September 20, 2022

**Re: Falcon Highlands South Filing No. 3 - Phase 1**  
**Case No. PUDSP225, Planned Unit Development, Preliminary Plan & Early Grading**  
Part of SW ¼ of Section 12, Township 13 South, Range 65 West, 6<sup>th</sup> P.M.  
Upper Black Squirrel Creek Designated Basin  
Water Division 2, Water District 10

We have reviewed the above-referenced proposal for phase one of the Falcon Highlands South Planned Unit Development, Preliminary Plan and Early Grading on approximately 17 acres in the SW ¼ of Section 12, Township 13 South, Range 65 West, 6<sup>th</sup> P.M. This phase proposes to plat the first 50 of 380 lots known as Falcon Highlands Filing No. 3. The Applicant is requesting a finding of sufficiency of water supply for the first 50 lots. **The comments contained in this letter only address the water supply for the first phase concerning 50 lots and do not provide an opinion of adequacy on all phases of Filing 3.**

Appendix A
Land Use Exhibits

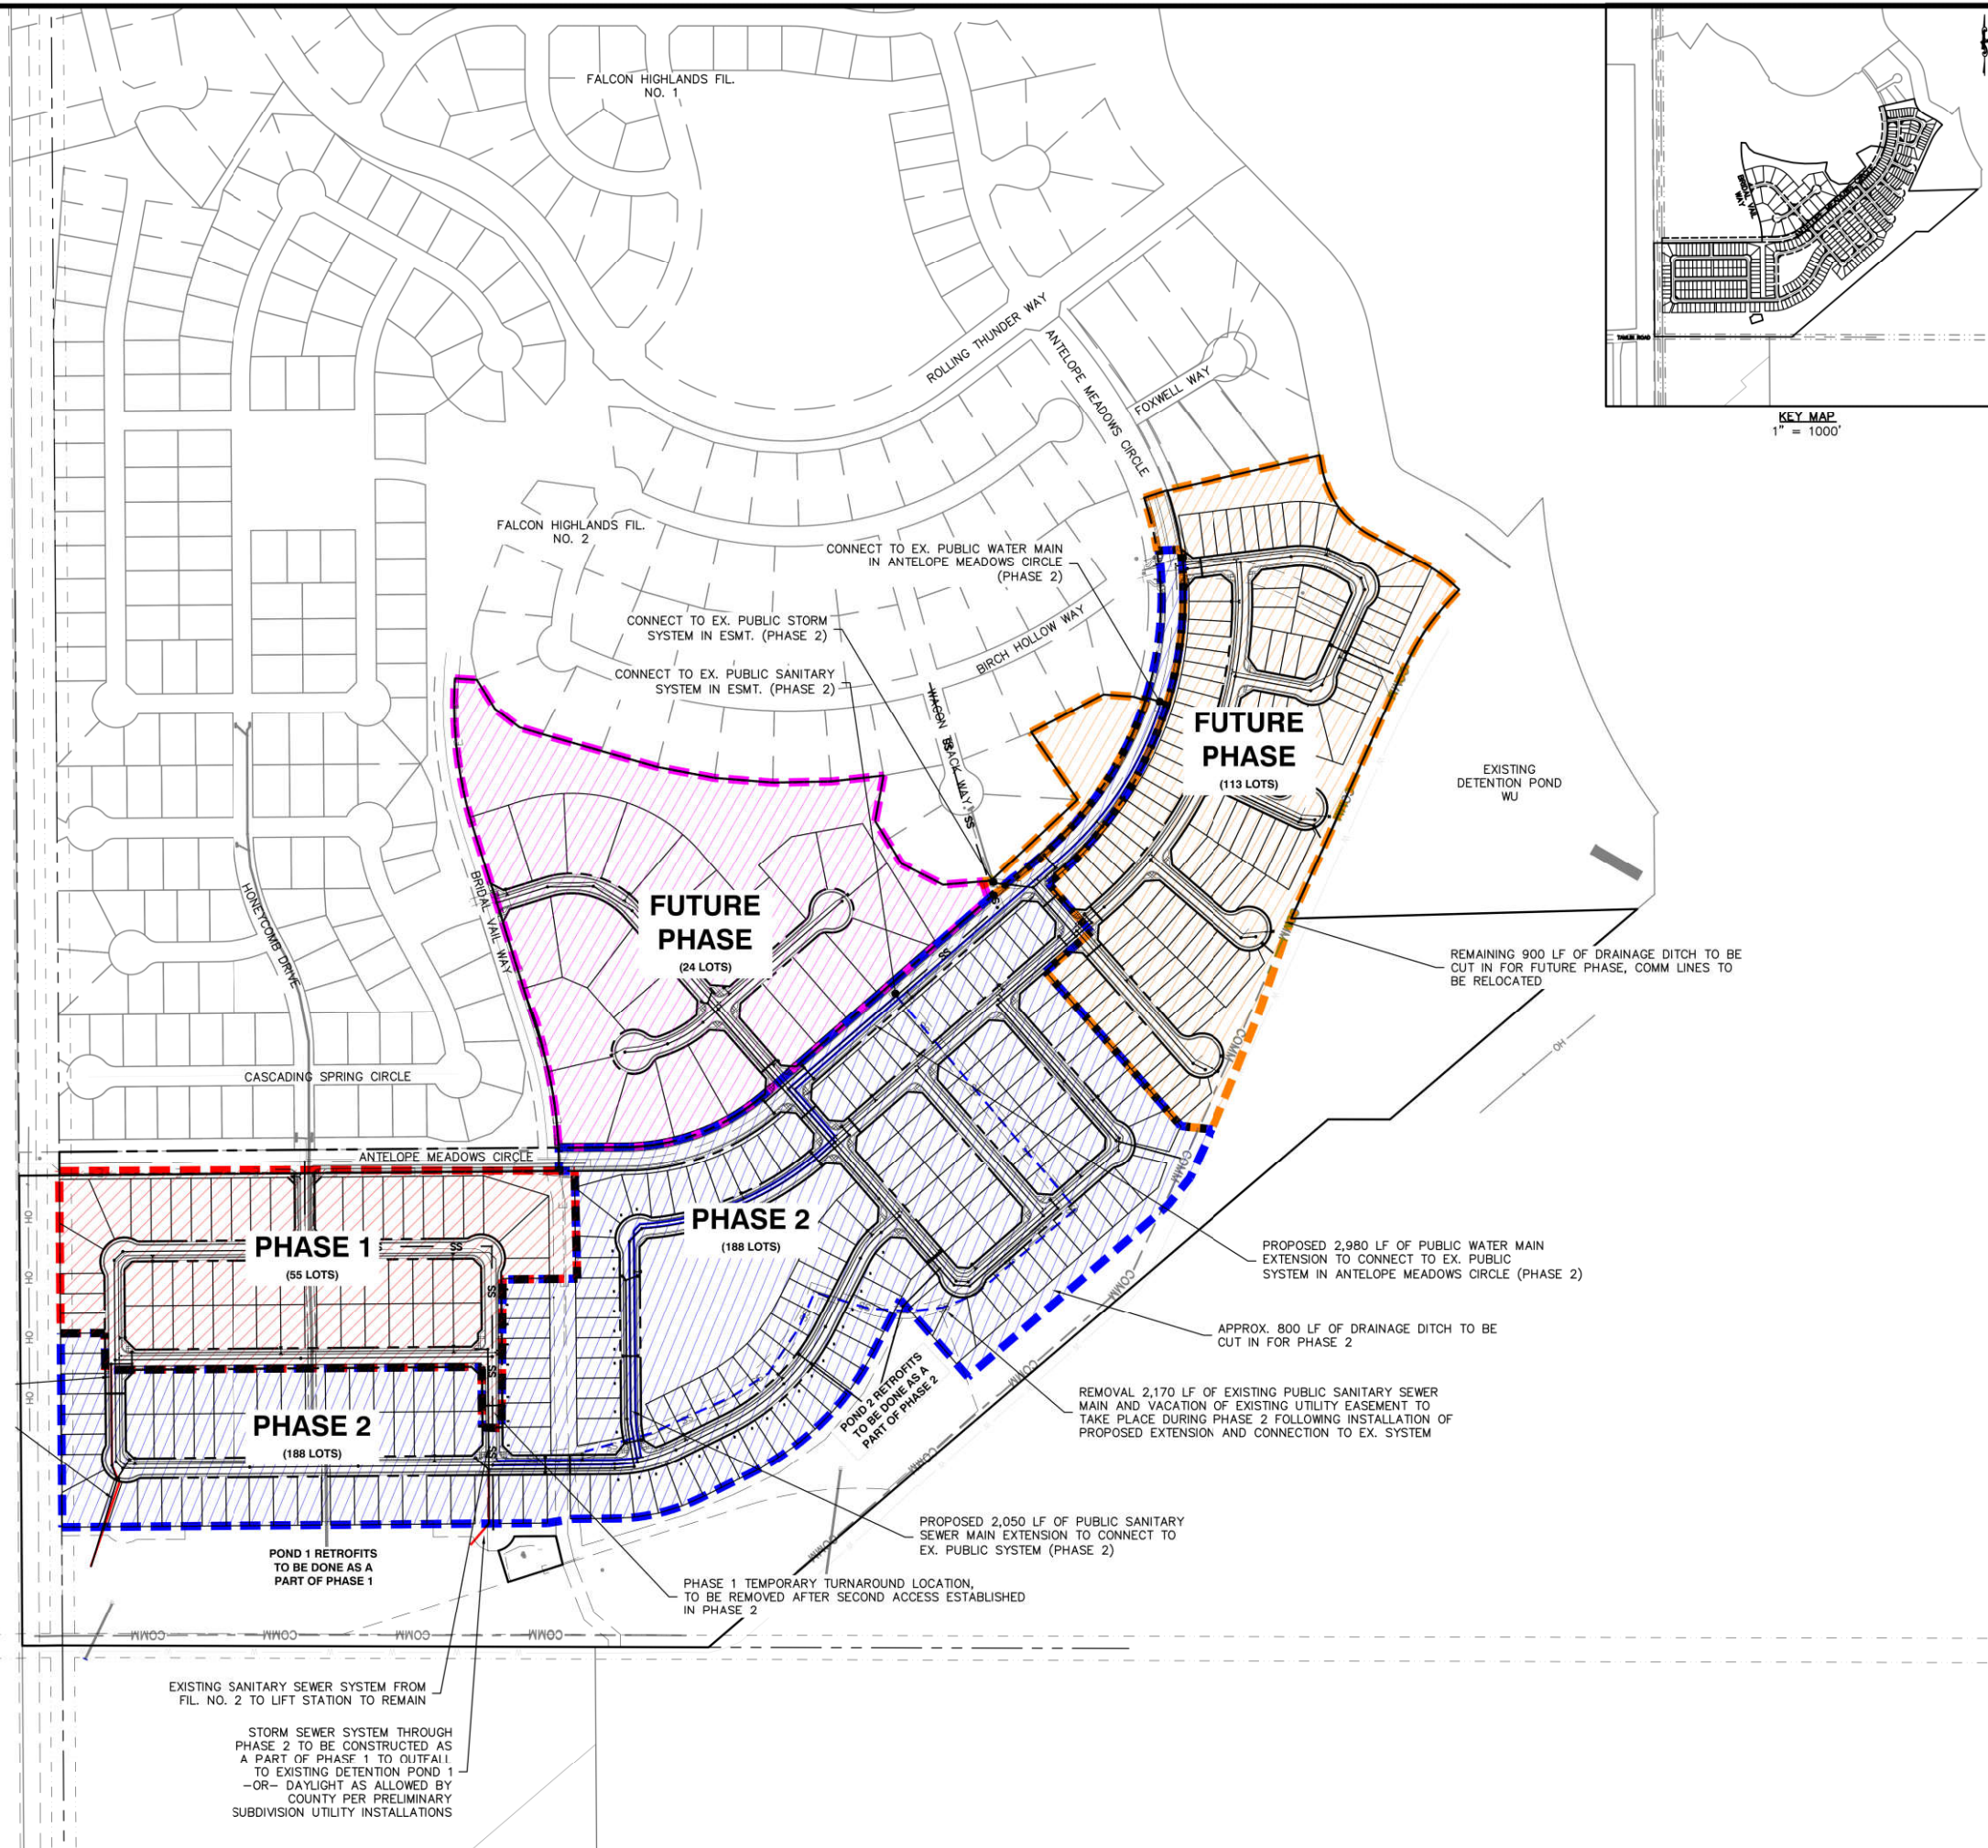
The initial maps provided show the platting of 55 lots in Phase I. The Applicant should provide an updated plat map of the first 50 lots to be platted.
